ENG-PPR19009-R3-CDs.pdf Markup Summary

Engineering Review
09/10/2019 12:55:32 PM
dsdrice
JsdRice@colorado.gov
(719) 526-7877
EPC Planning & Community
Development Department

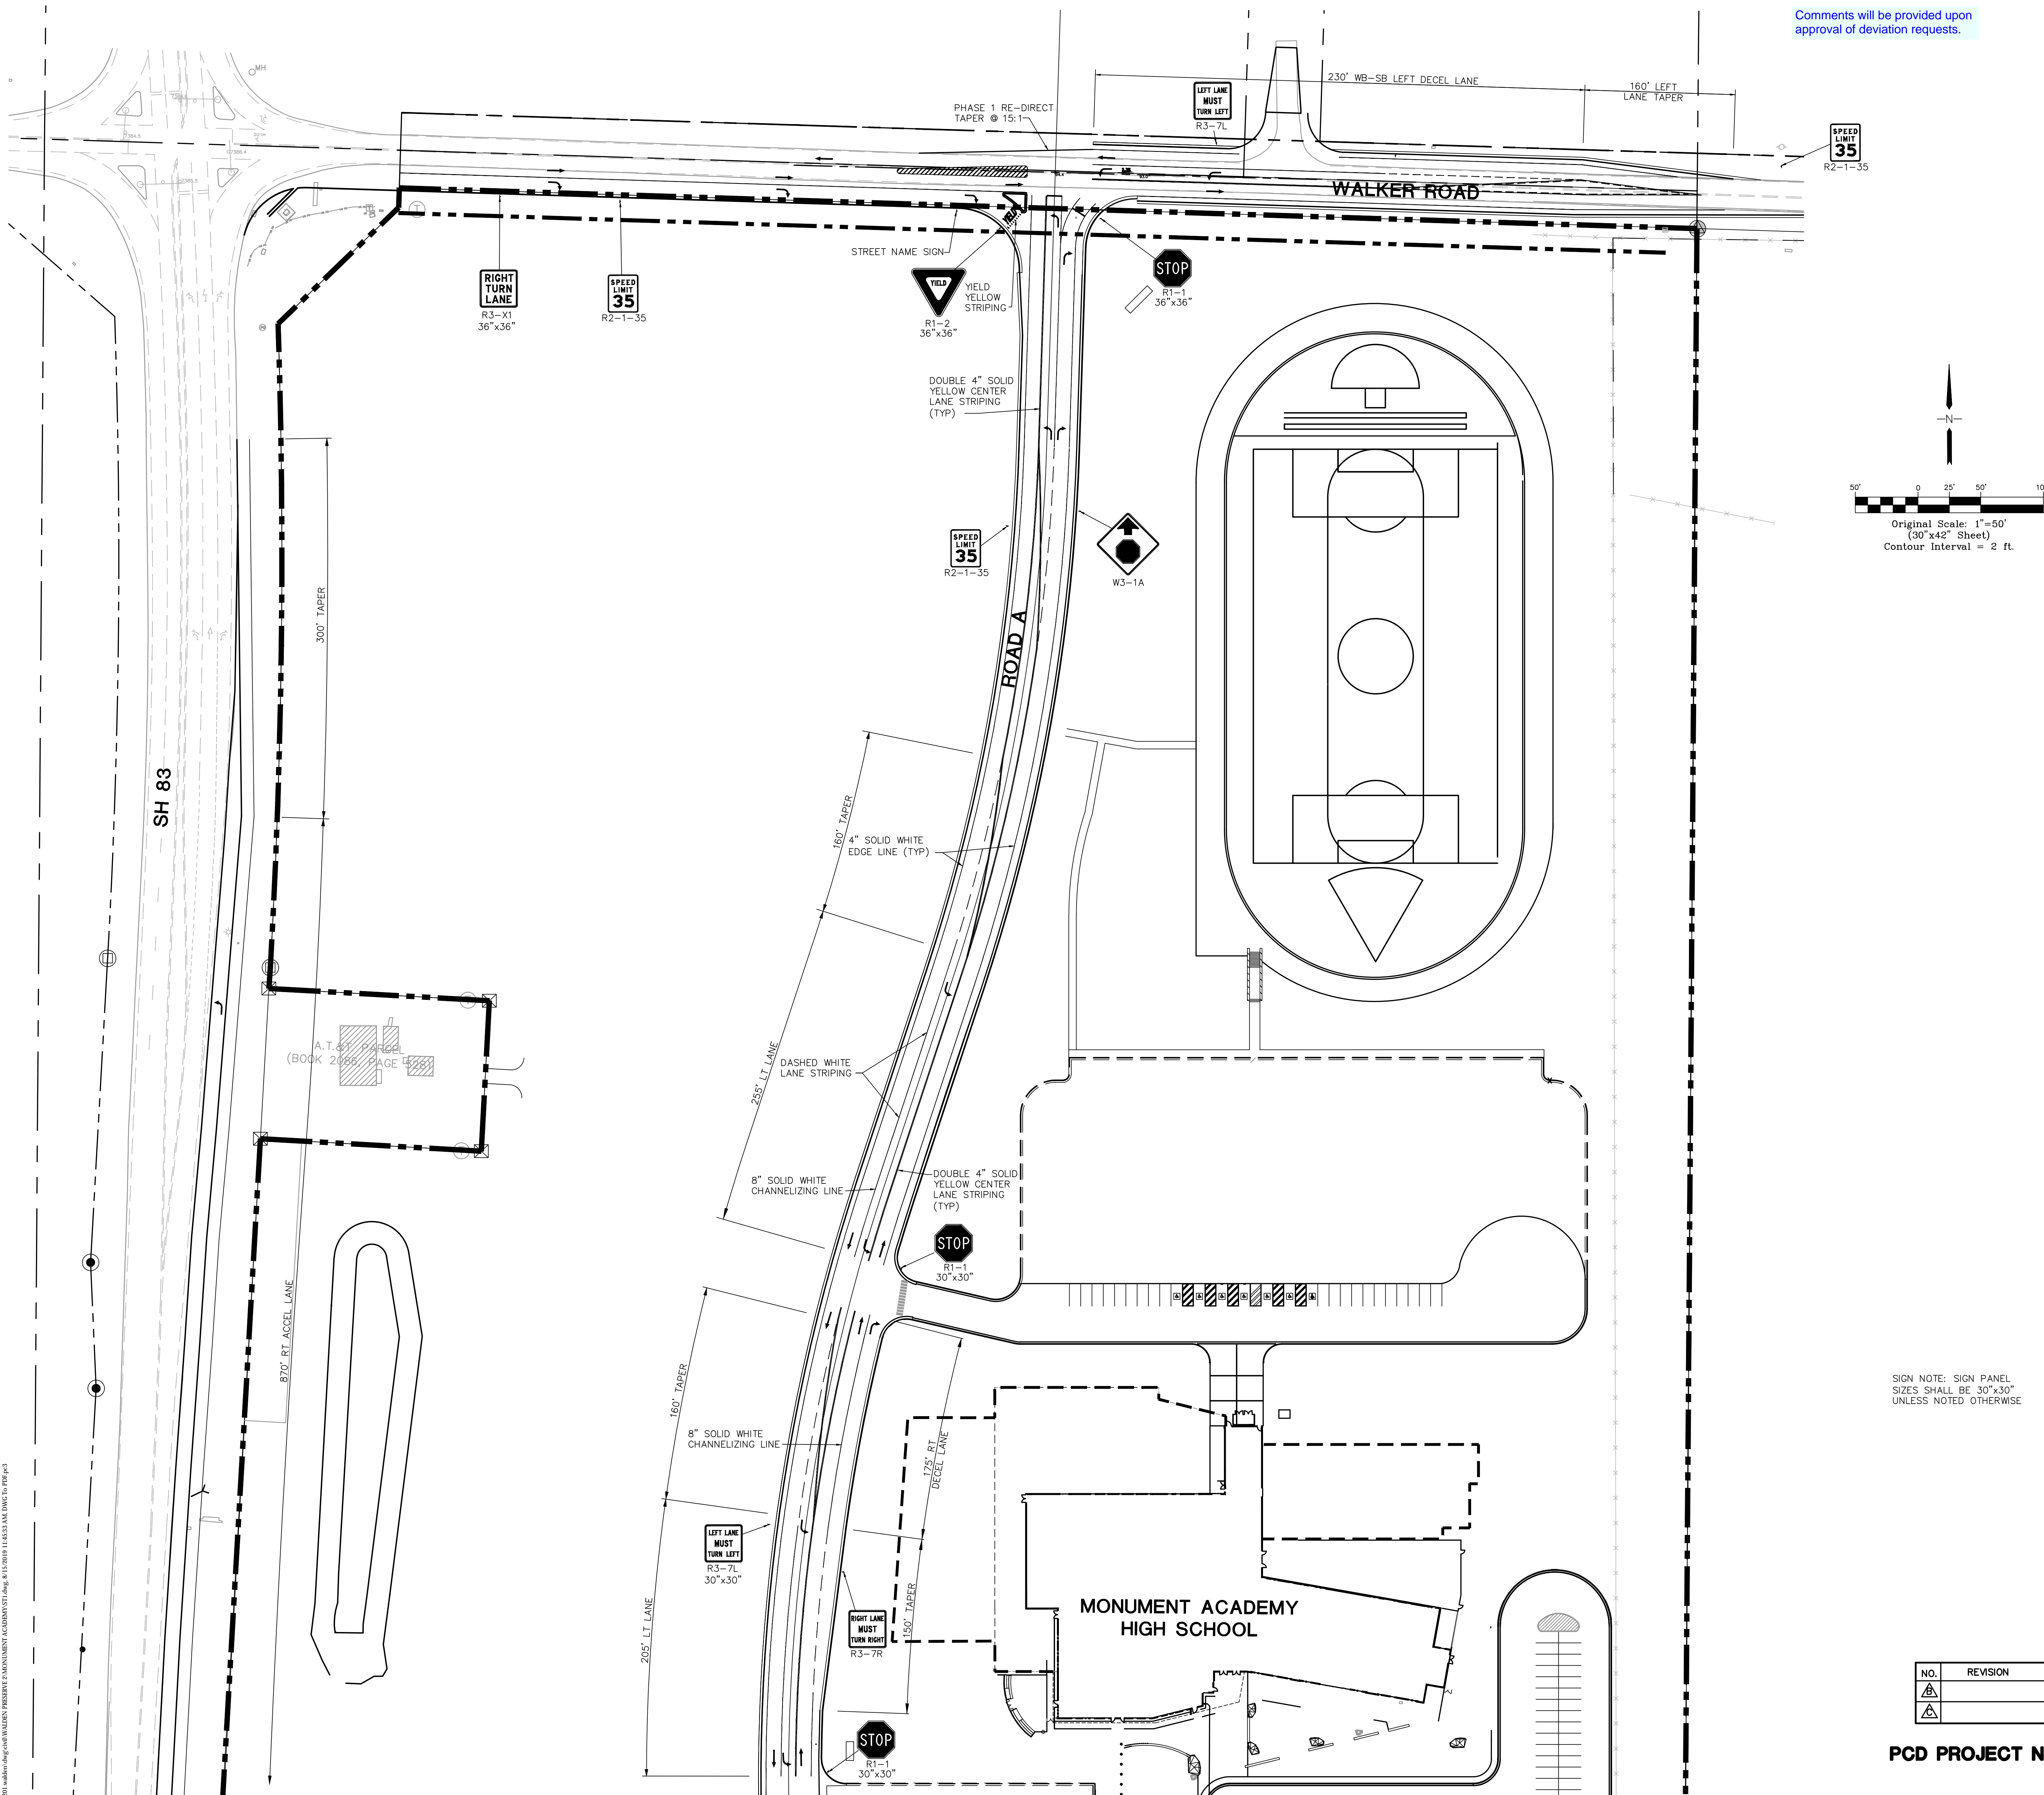
Comments will be provided upon approval of deviation requests.
